Our ref: Marsden Park Data Centre (SSD-70889211)

Subject: Additional Matters for Submissions Report (SSD-70889211)

The Department's comments on the Environmental Impact Statement (EIS)

5 FRONT ELEVATION (FOH) - Type A  
1 : 250

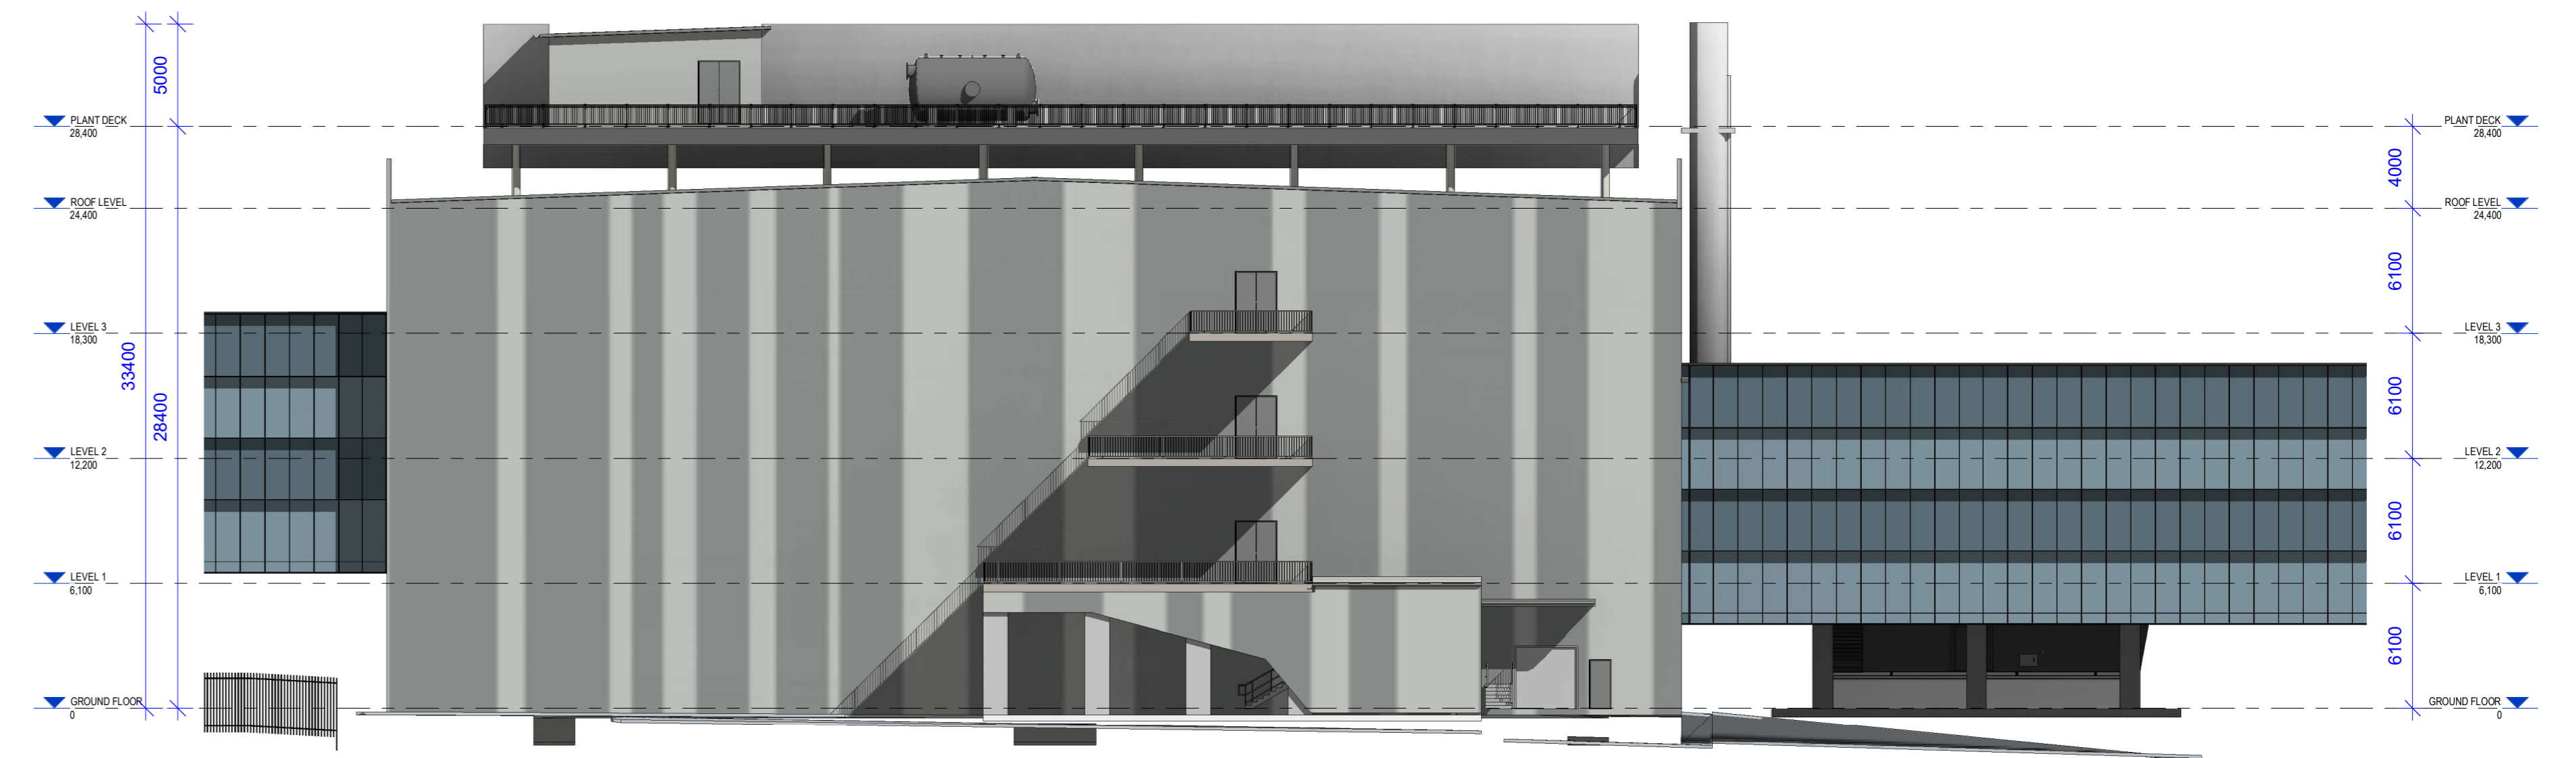
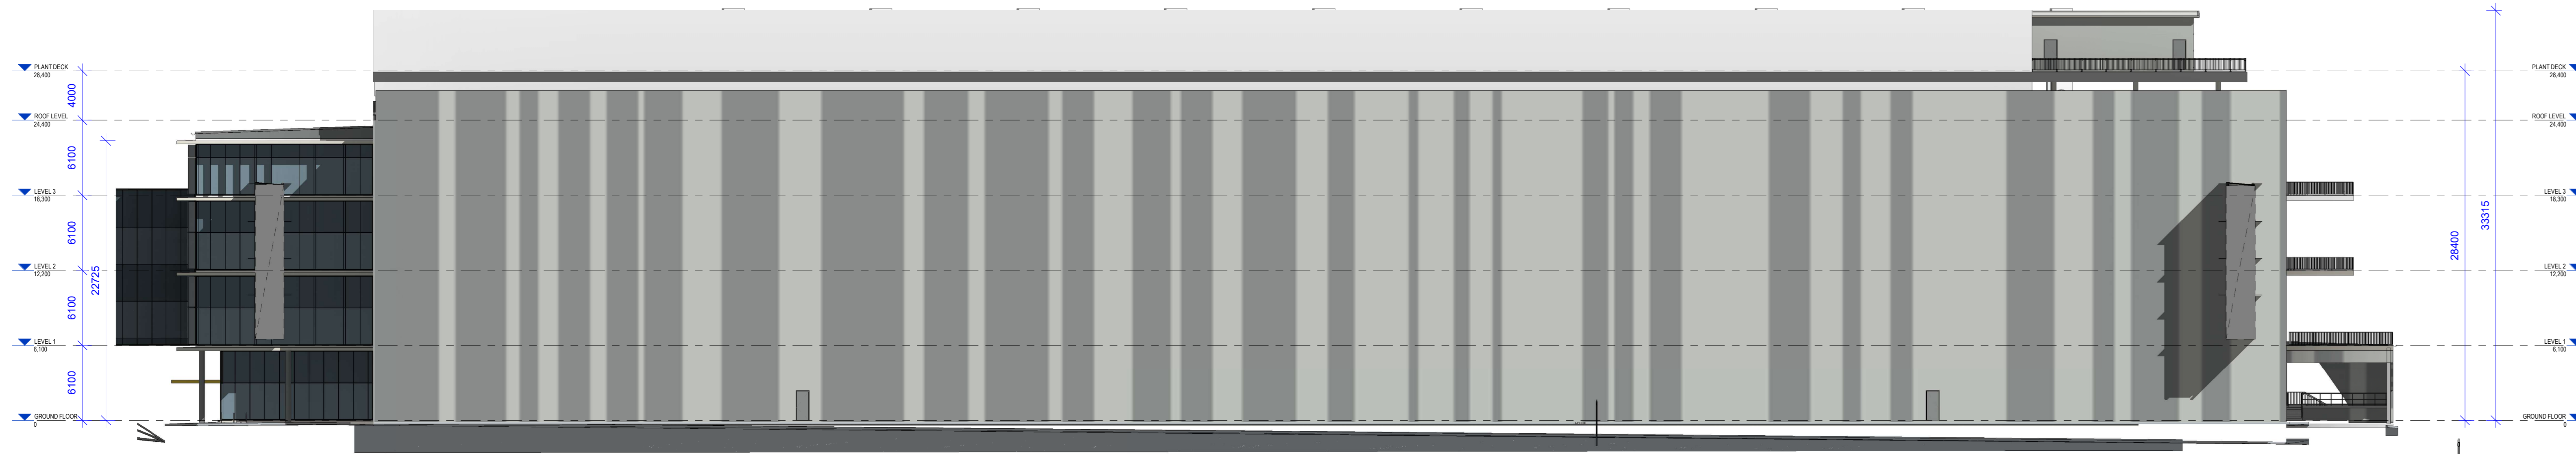
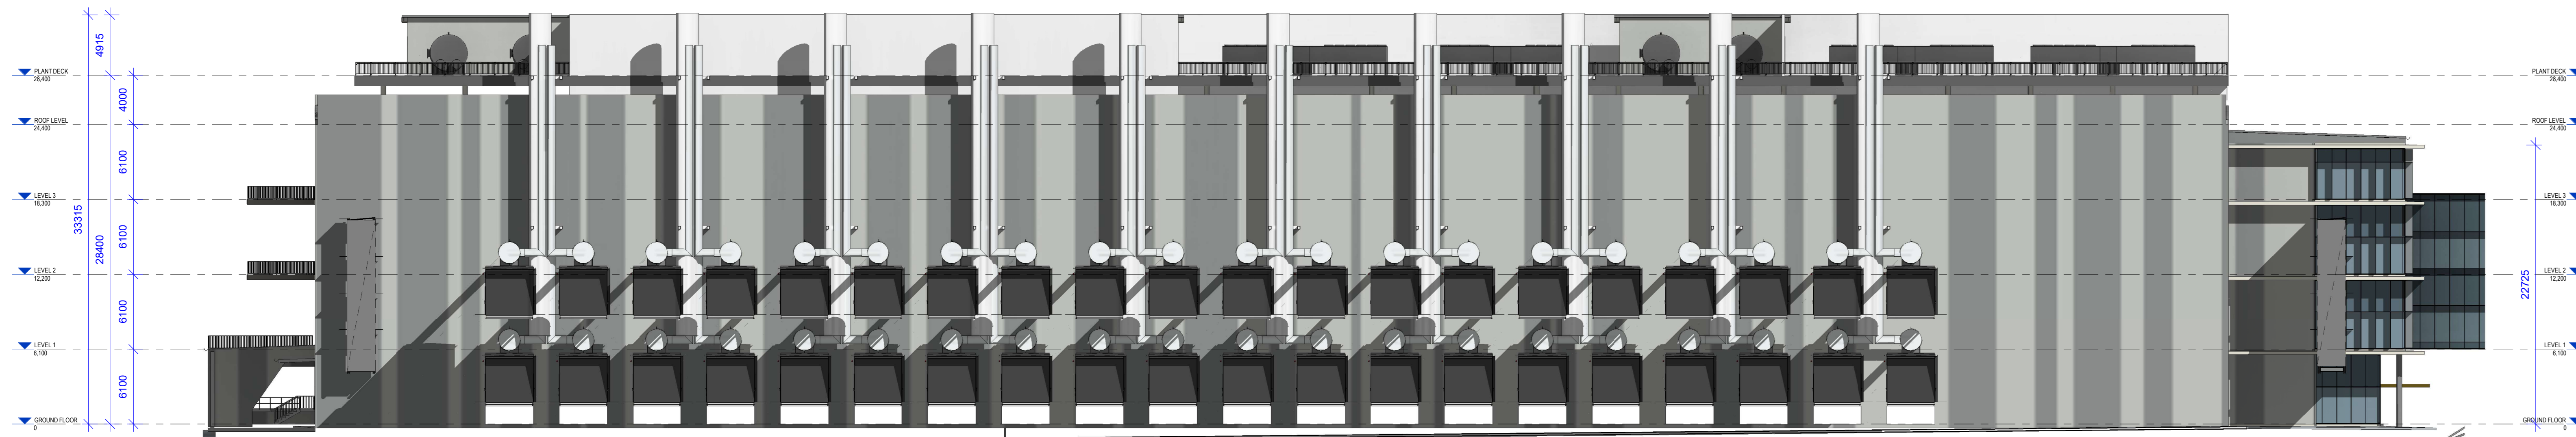
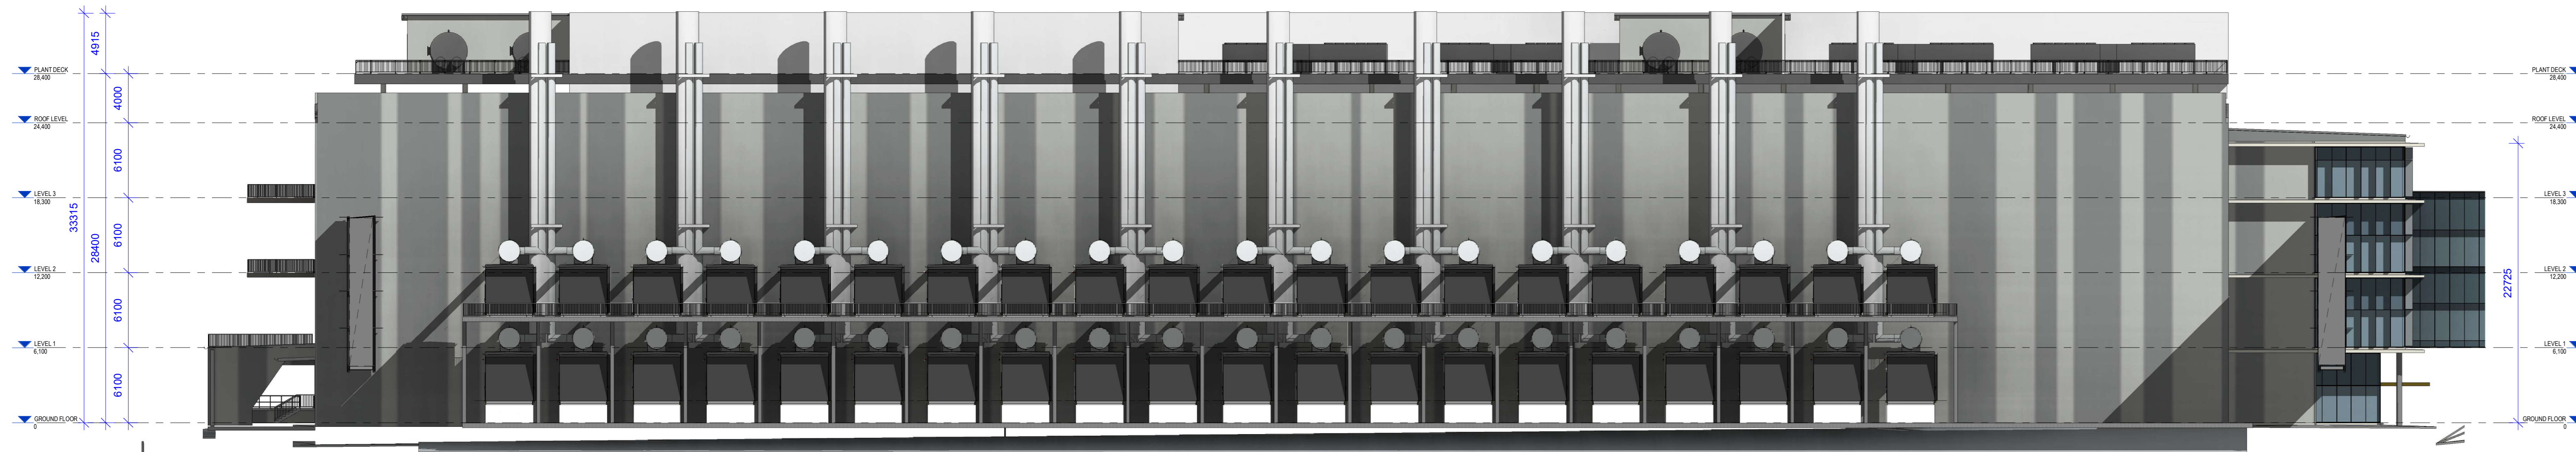
28. Given the proposed acoustic barrier treatments differ across each building, please provide detailed architectural plans for each of the six data centre buildings proposed under the subject SSD application.
29. The Department has concerns regarding the design of the development’s southern and eastern façades, particularly when viewed from residences to the south of the site.

In this regard, consideration should be given to improving the design of the development's southern and eastern facades so as to demonstrate design excellence and further soften the appearance of each data centre building. Such improvements could include, but are not limited to, the use of additional articulation and/or an alternative colour palette.
